Subject: FW: BR/128/20/DOC, 9 Westloats Lane

Engineers Comments Regarding Surface Water Drainage

Project
 Proposed Site Plan
 Date
 2nd May 2018
 Scale
 1 : 500

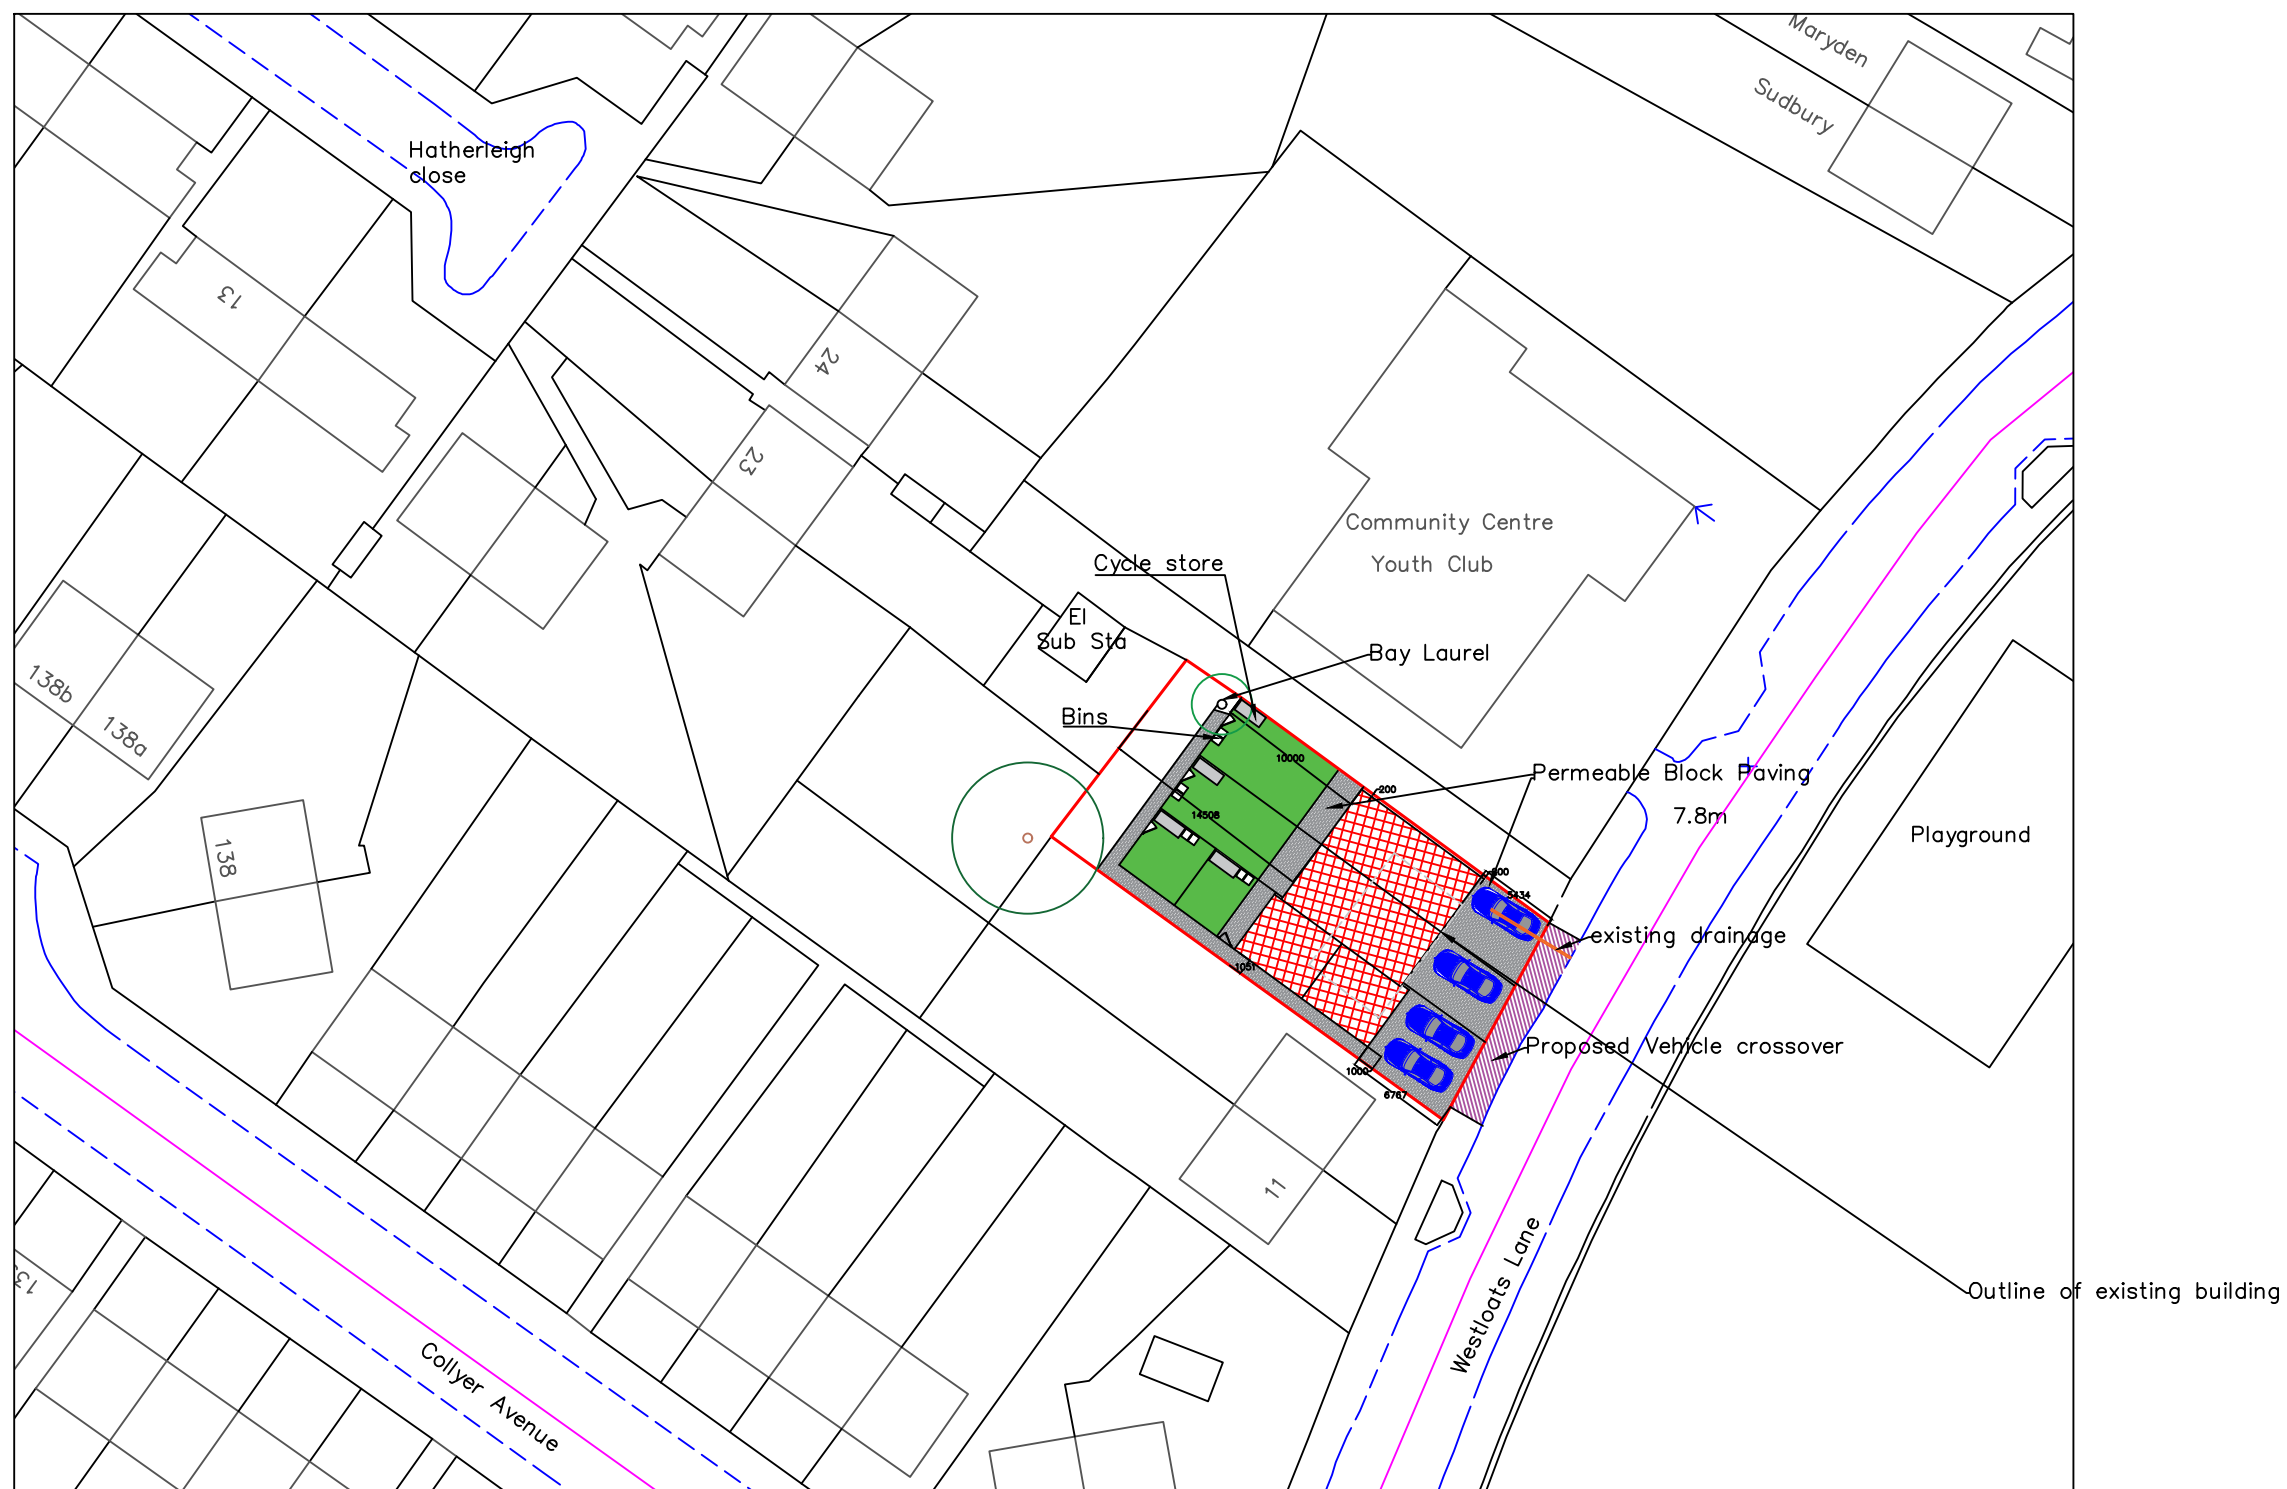
6. Permeable paving is noted on the site plan, but there are no calculations for this. Nor is it included in the drainage layout. Nor do we have a construction detail for it.

Project Proposed soakaway Plan	Sheet 4
Date 13th May 2020	
Scale 1 : 500

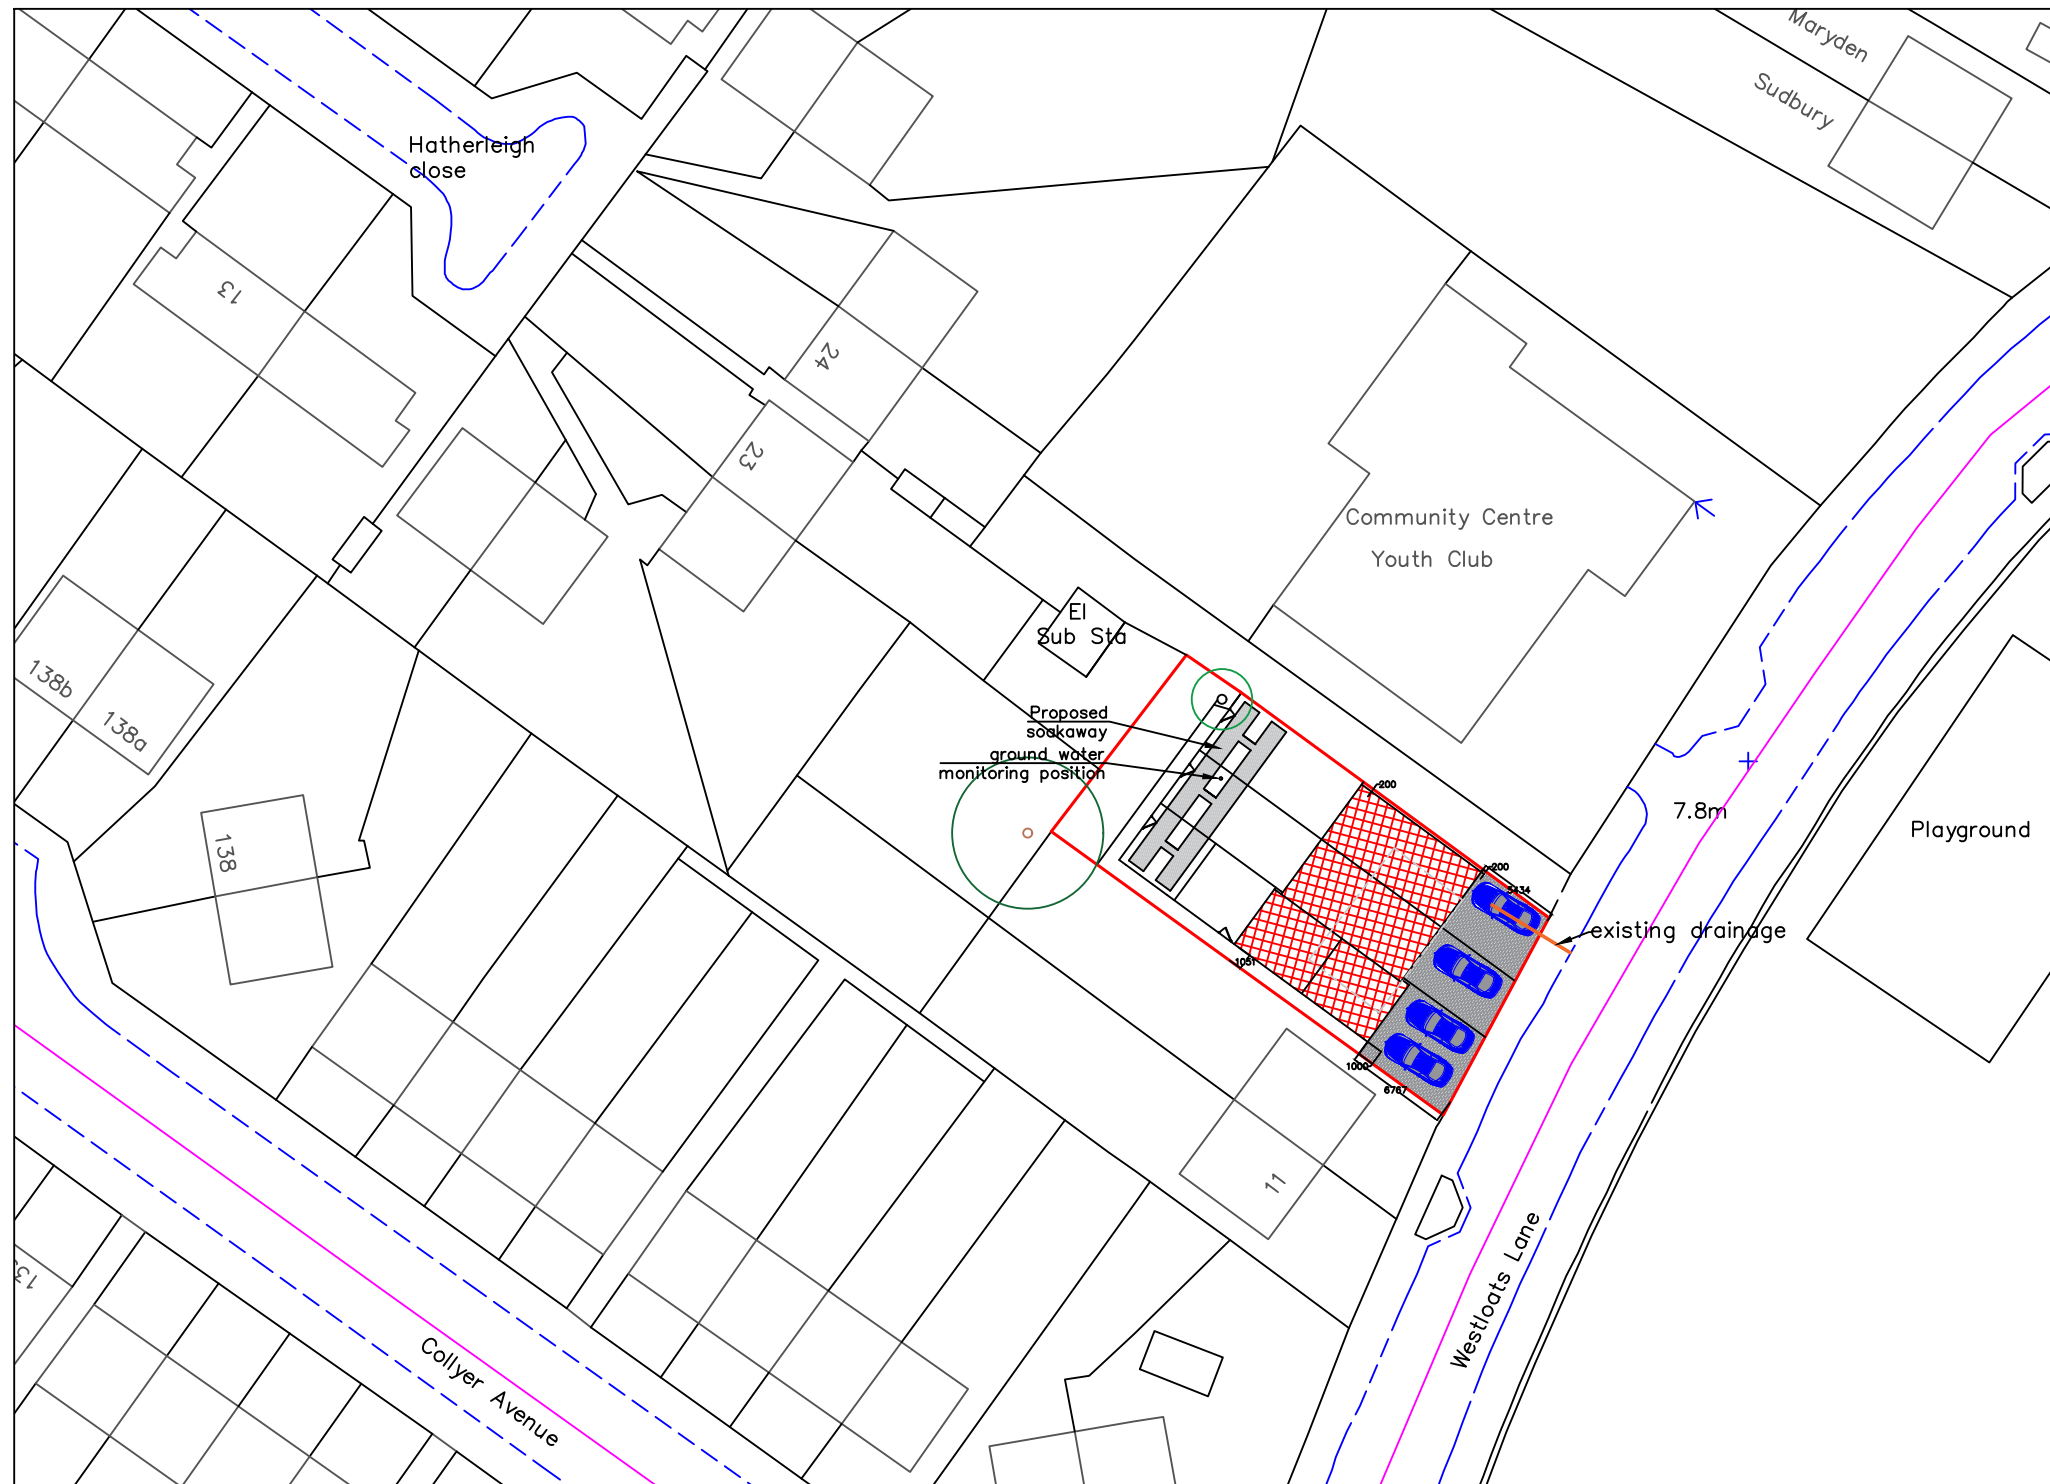
4. The Soakaway Plan does not include the necessary level of detail as described in the Drainage Checklist. (Pipes, silt traps/manholes/inspection chambers, invert levels, cover levels, gradients/falls).

5. No construction detail drawings have been supplied (Soakaway, silt trap, pipe bed and surround minimum).

7. Any soakaways need to be kept a minimum of 1.5m from the property boundaries.

- 1, The calculation is correct Sarah made an error
- 2, Three tests were carried out and the worst case was used, the other tests are now noted on the calculation sheets.
- 3, Using the correct infiltration figures I supplied this does now drain within 24 hours
- 4, See attached new plan
- 5, see attached new plan
- 6, Permeable paving is shown on the plan and construction details from Marshalls are attached, they are not included in the calculations as no surface water from these areas is added to the drainage system.
- 7, Drawing amended to take this into account

Project Proposed soakaway Plan	Sheet 4A
Date 13th May 2020	
Scale 1 : 500

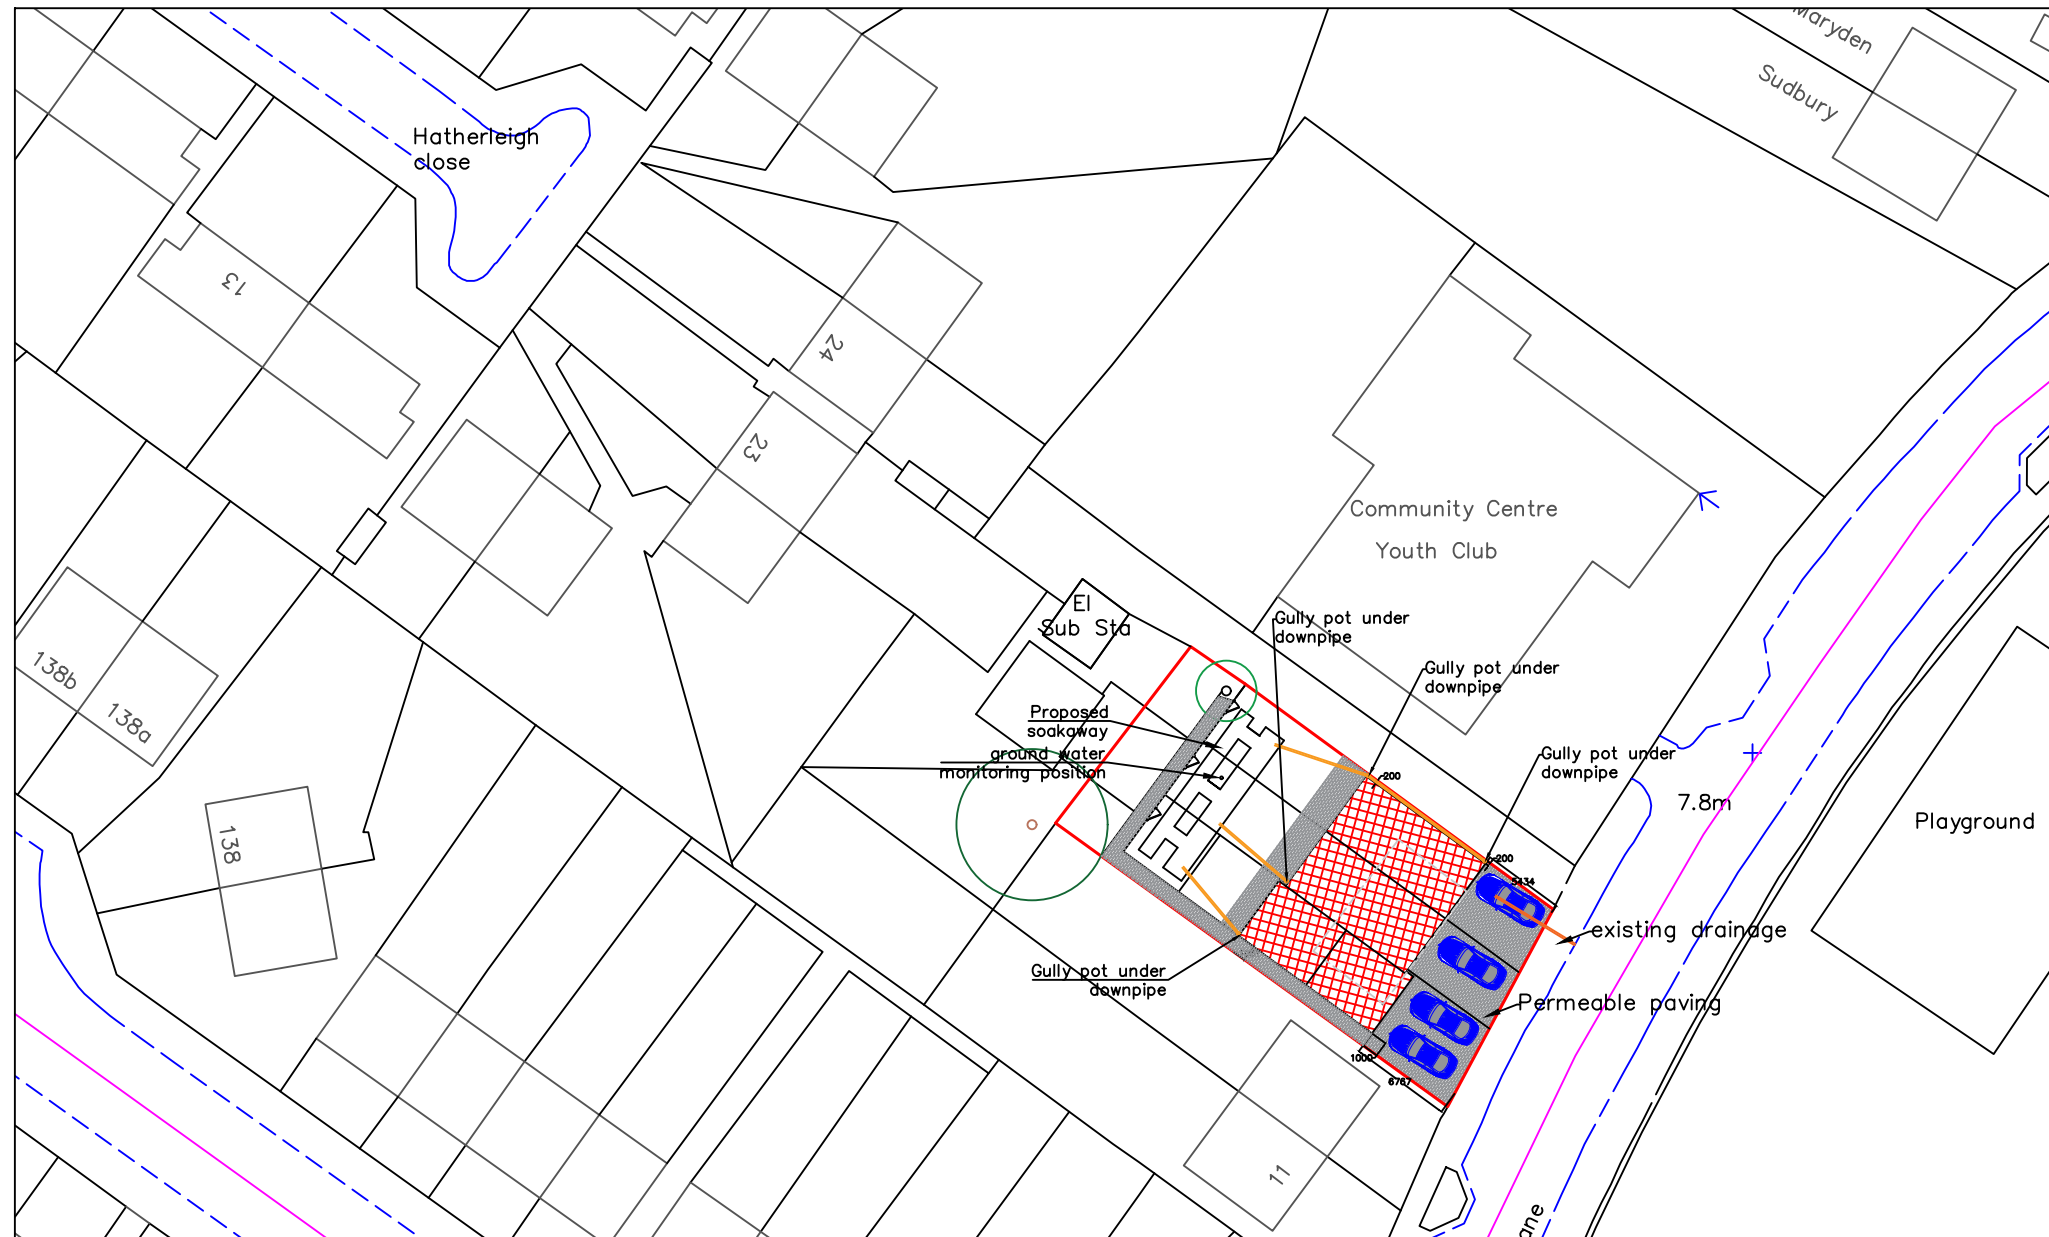
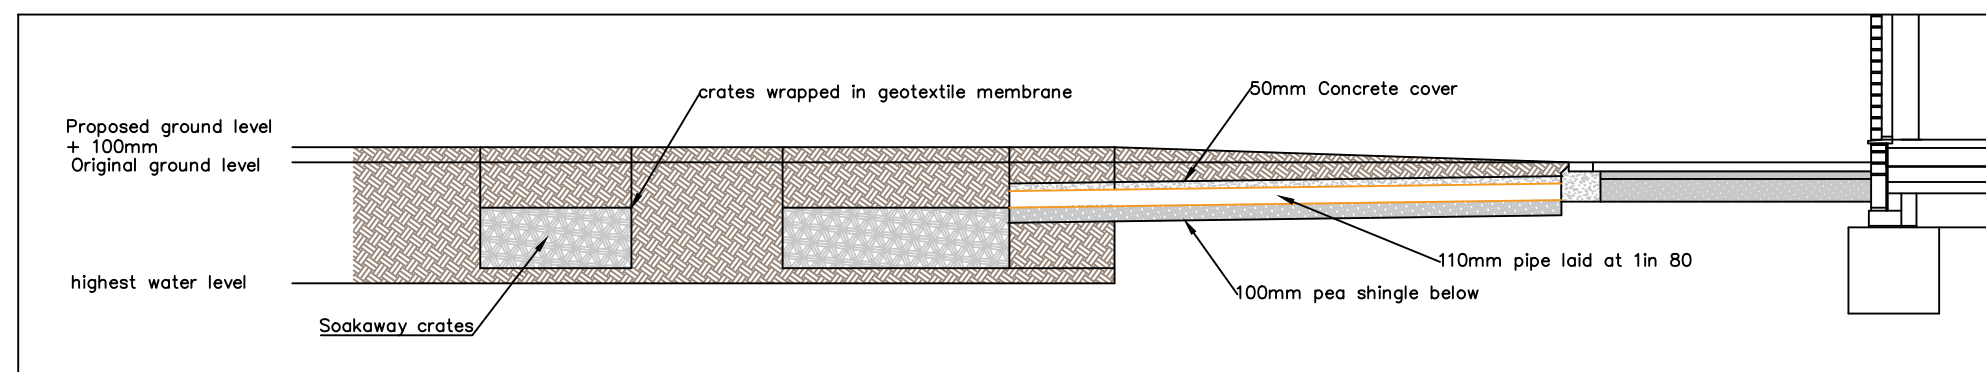
With regards to the Drainage Layout and constructions details the following points need to be addressed:

1. Invert and cover levels for all components (including soakaway) need to be shown on the drainage layout.
2. The cross section needs to show the pipe going into the side of the crate rather than into the ground above it.
3. Please specify no fines in permeable paving and that it should be fully wrapped with a permeable membrane.
4. Given that the base is now to be utilised in the calculations please include silt traps (in addition to or opposed to the gully pots) upstream of the soakaway. Every opportunity must be made to avoid siltation as the base is the primary infiltration surface.
